Re: Wal-Mart at Lester and Wyoming, Development Application #, Project #PR-2021-005461/SI-2021-00680

Please find responses below in bold addressing the Transportation Development Comments received May 12, 2021.

DEMOLITION PLAN - PROPOSED LOCATION PICKUP PARKING
SCALE: 1"=20'

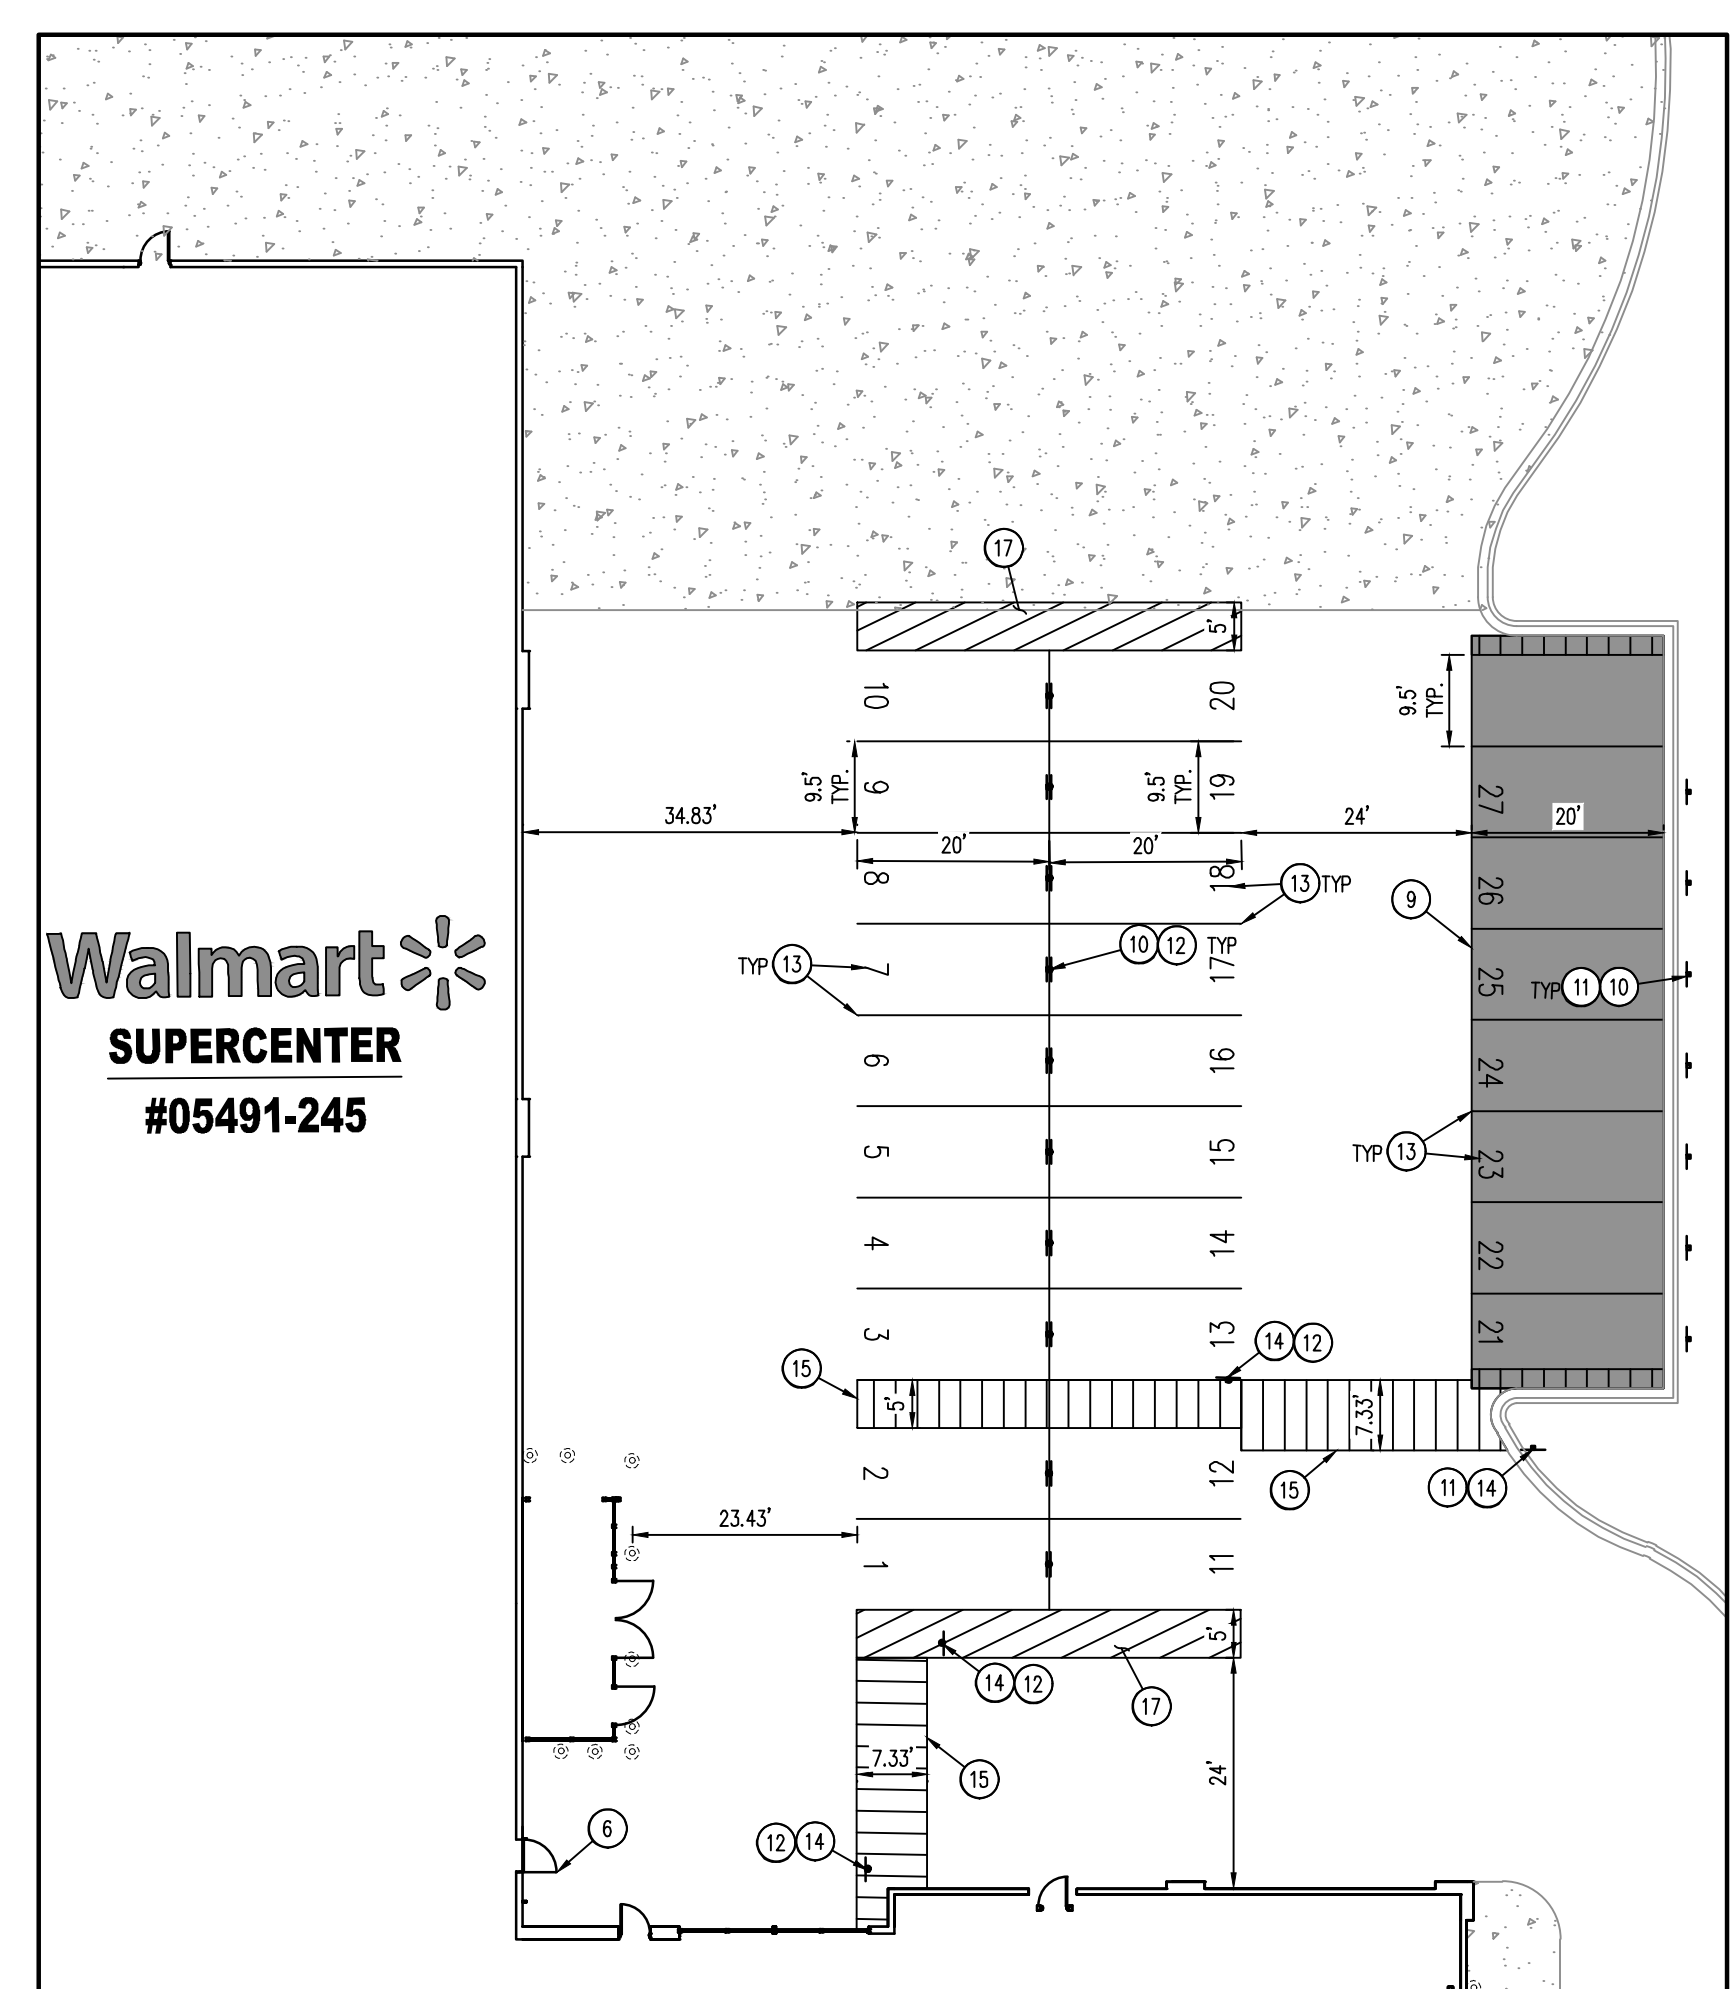
3. On the SECP-2 sheet, include dimensioning for the new pick-up spaces, crosswalks, driving aisles, etc.

Response: SECP-2 has been updated to included dimensions as indicated. In addition, plan sheets CS1, CS2 and CS3 have been added to the plan set. The requested details are also included on the CS1 plan sheet.

SHEET: **CS3**

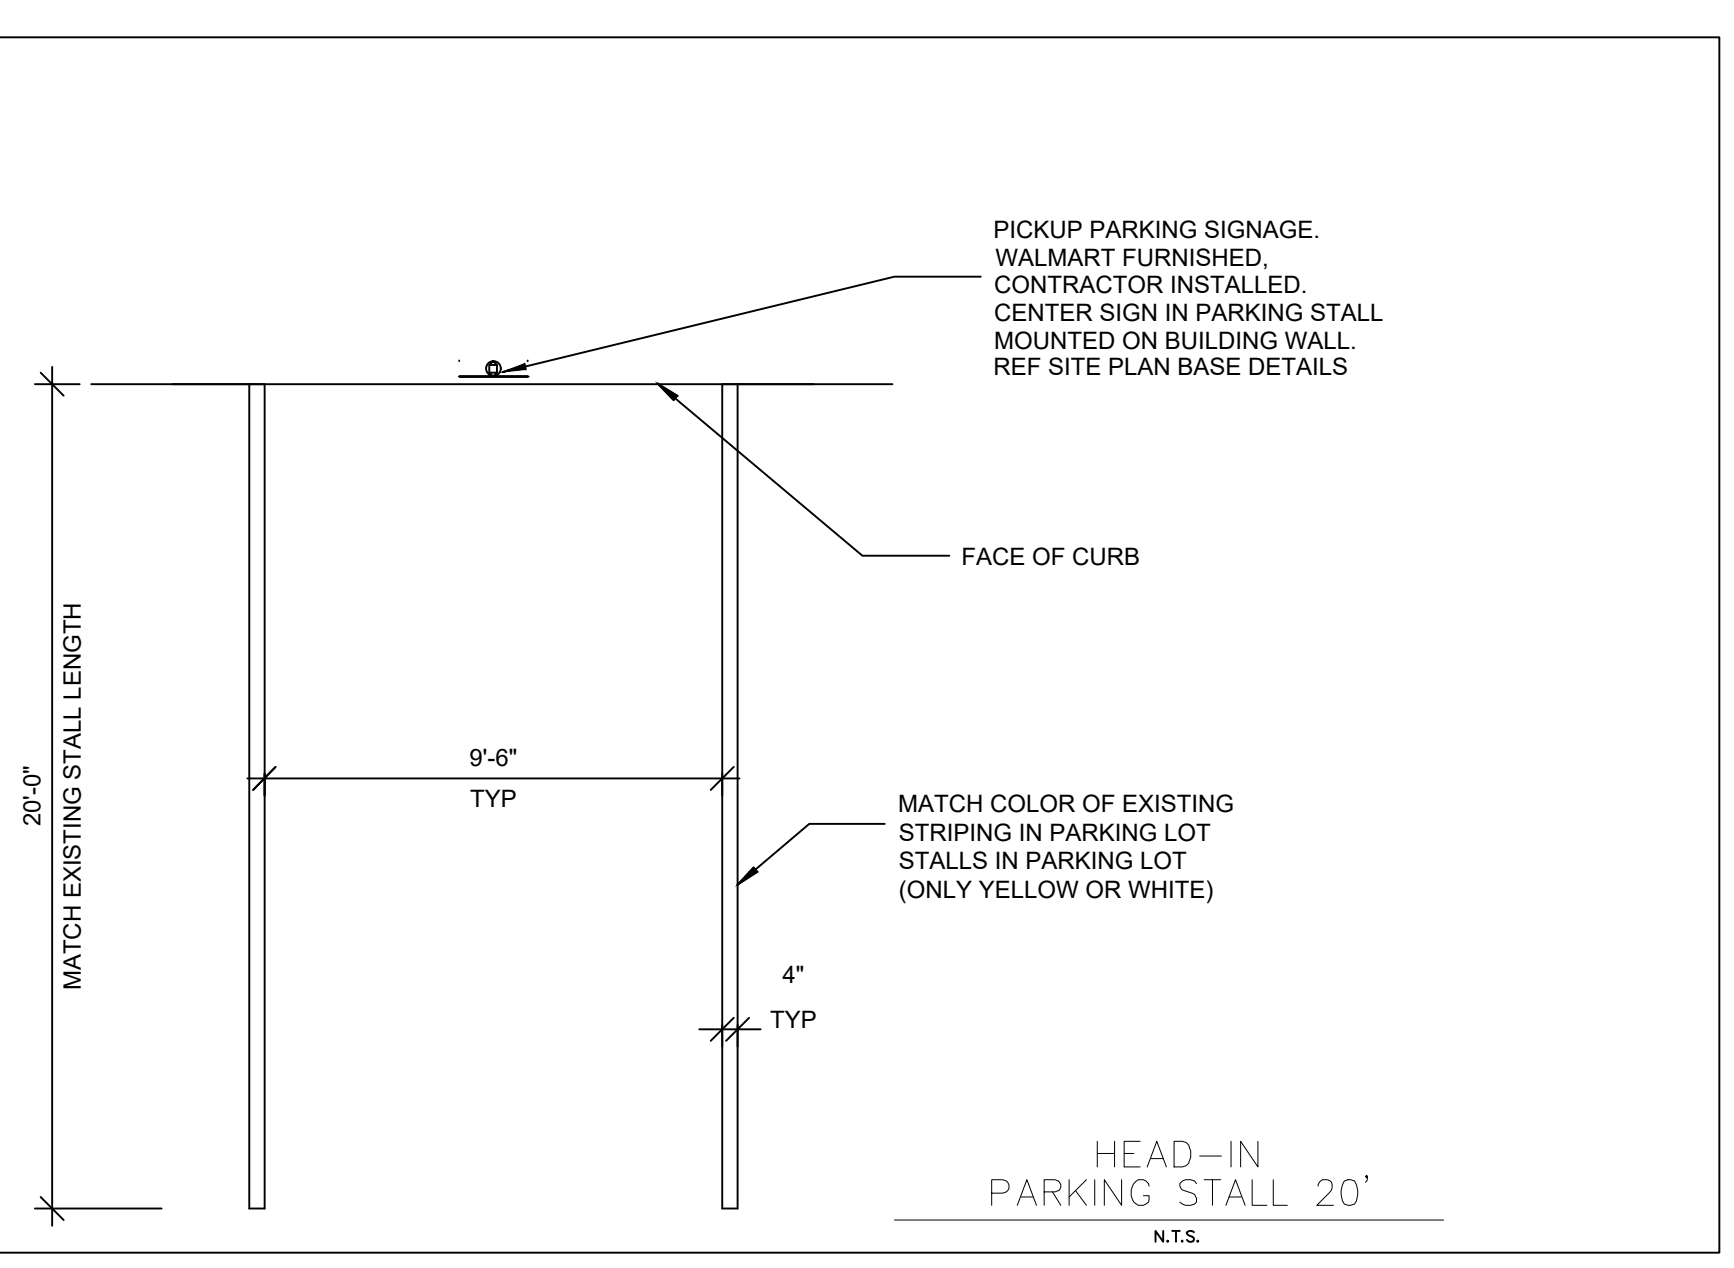
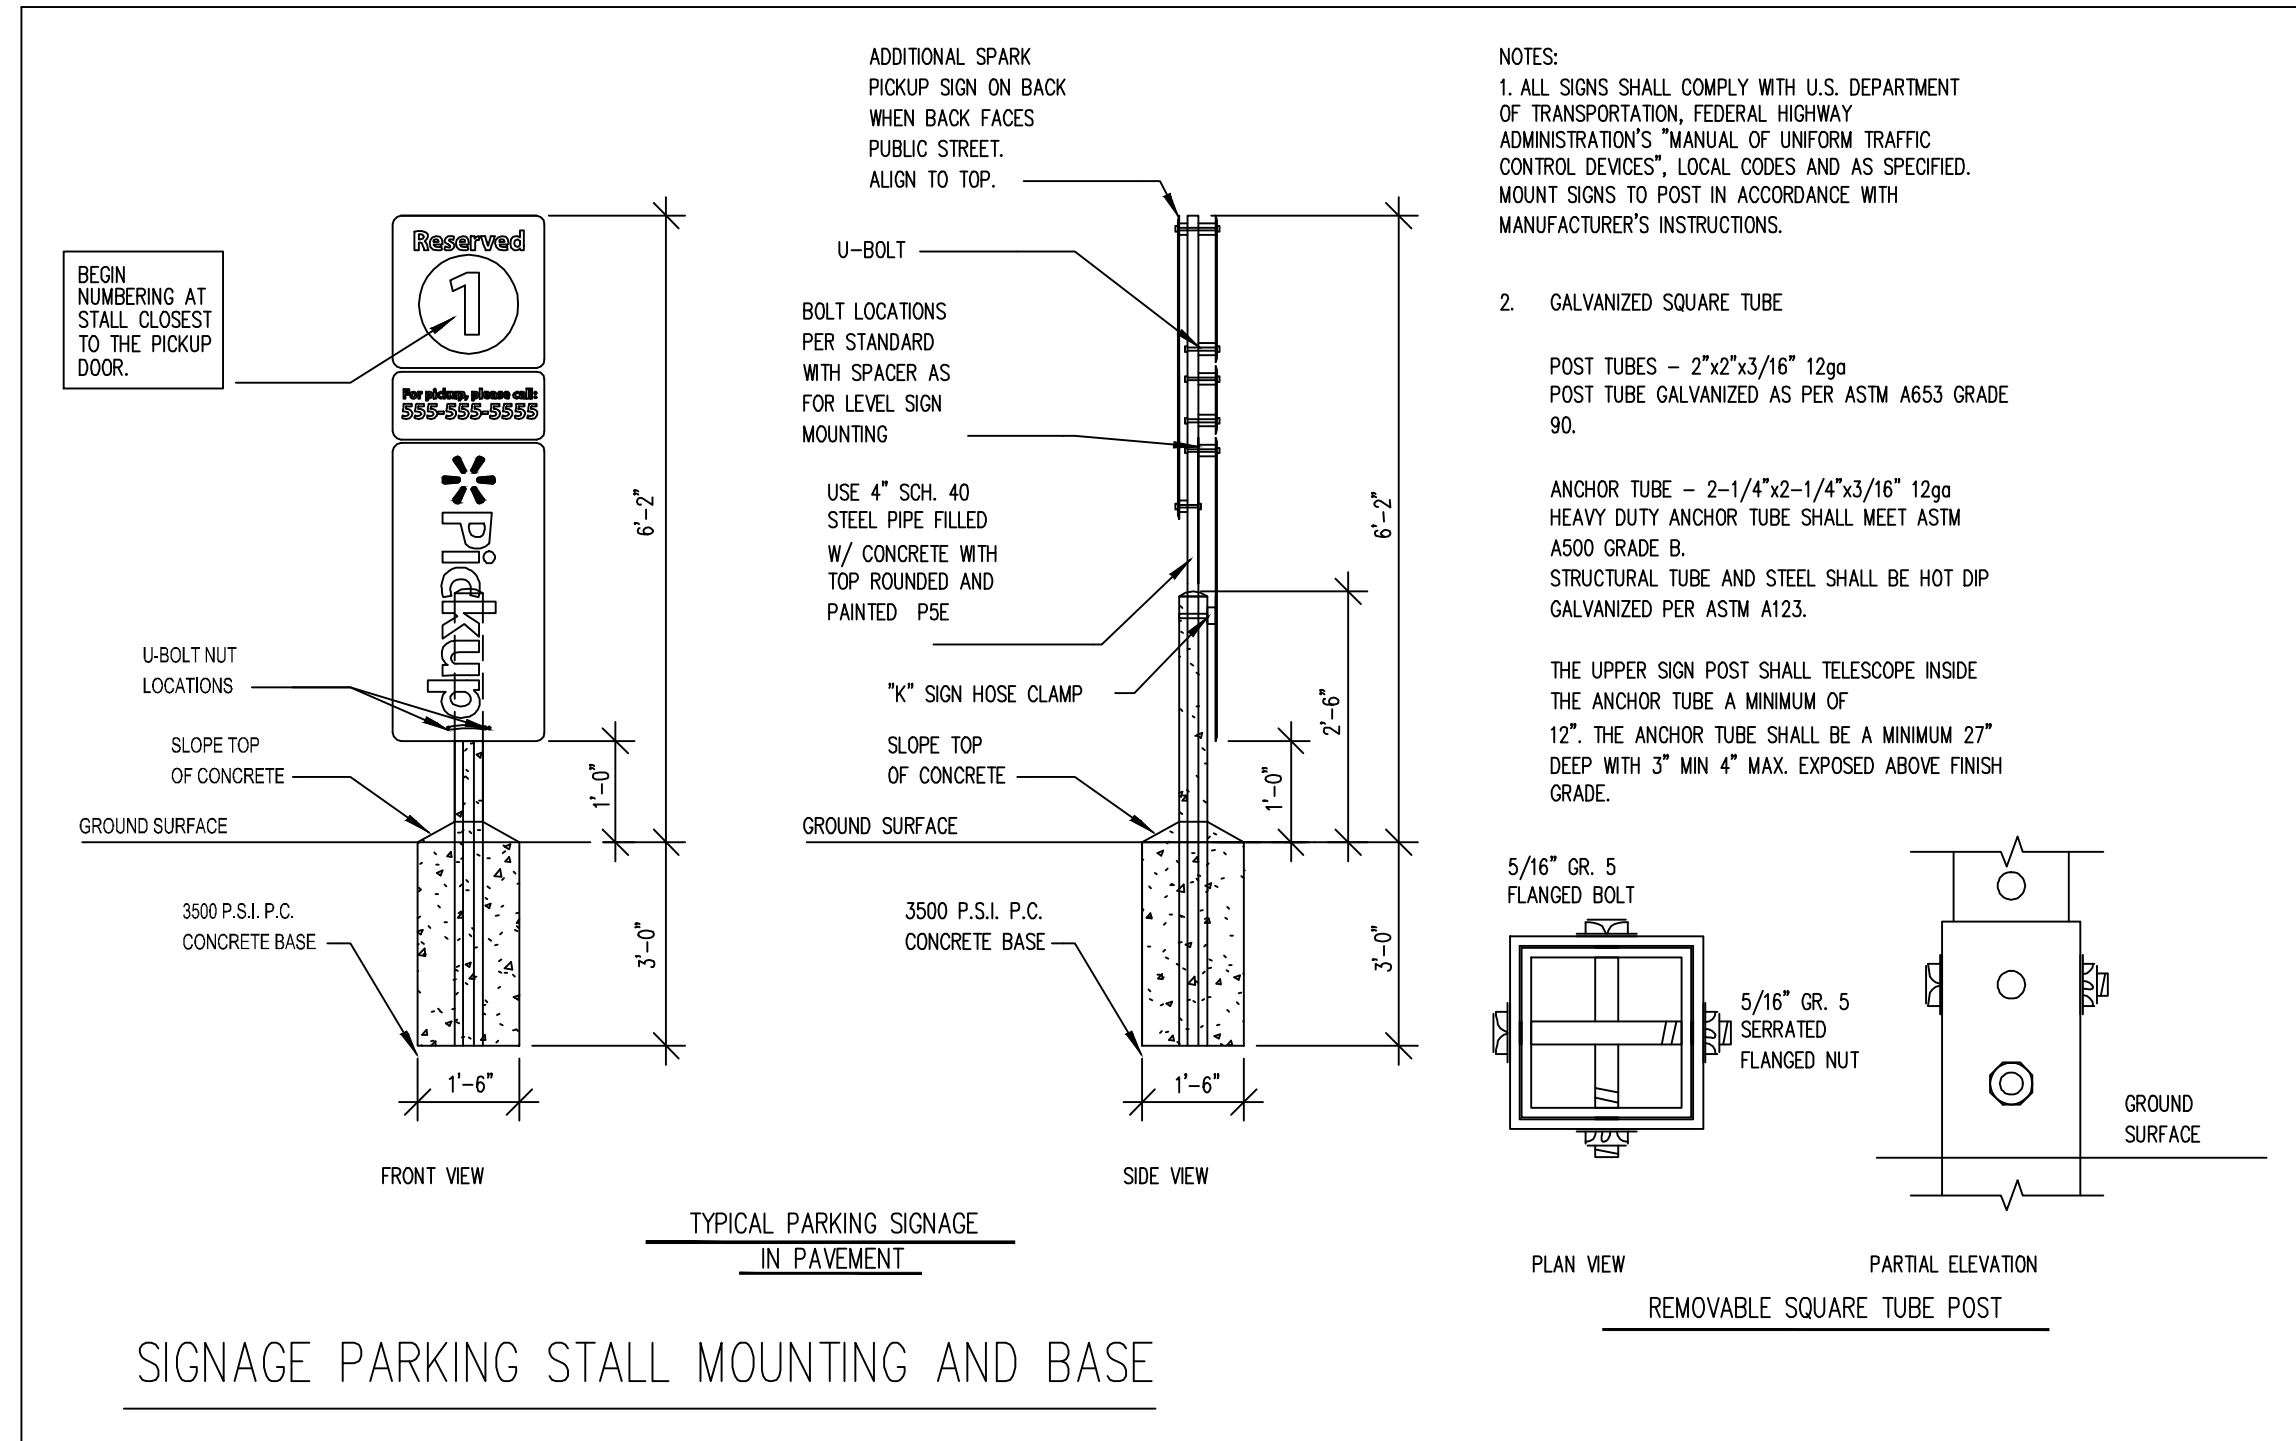
1. I did not see a Wayfinding sign plan in this submittal for the pickup-up spaces.

Response: A Site Signage Plan has been added to the plan set directing traffic to the proposed Pick-up parking stalls, Ref. CS2.
